CONSULTEE RESPONSE (Council's Arboriculturist)

Case Officer: Silvie Steiningerova
Reference: AW/117/26/T
Location: 31 West Drive, Aldwick, PO21 4LY
Proposal: Reduce height to 11-12m and reduce spread to 4-5m to 1no. sycamore tree (T1).
Reason: Long-term clearance of dwelling

Photographs of Sycamore, outside 31 West Drive, Aldwick Bay Estate

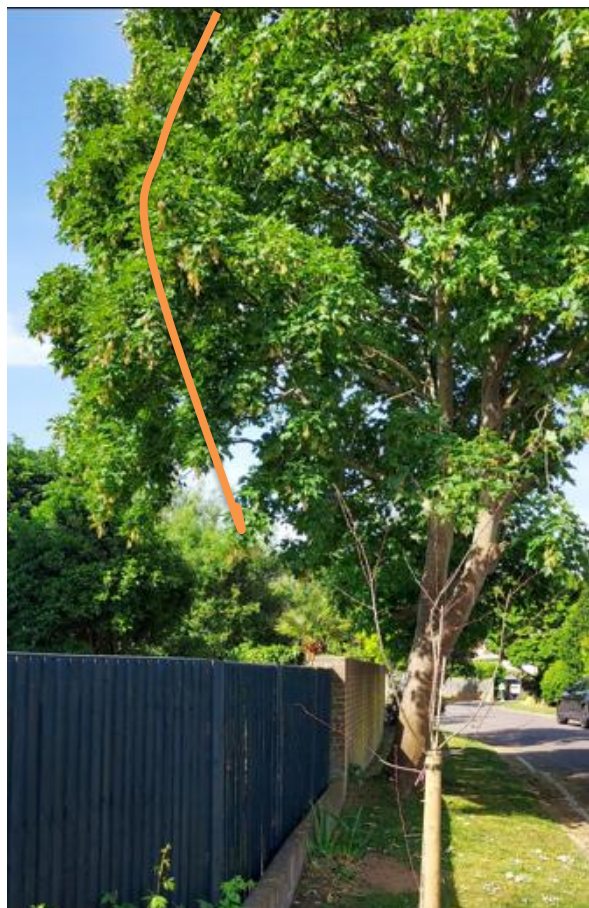
The extent of crown spread pruning is minimal, as limited to that which is illustrated on the submitted photographs; those can be used to ensure compliance with any consent. A reduction in radial crown spread will only occur on the south aspect.

Part a) Where whole branches are to be removed and final cuts made close to the trunk or branch union they are to be made as shown in Figure 2 of BS3998:2010

Part b) Where branches are to be shortened back the final cuts are to be made at the correct angle shown in BS3998:2010 and adjacent to a live bud or lateral.
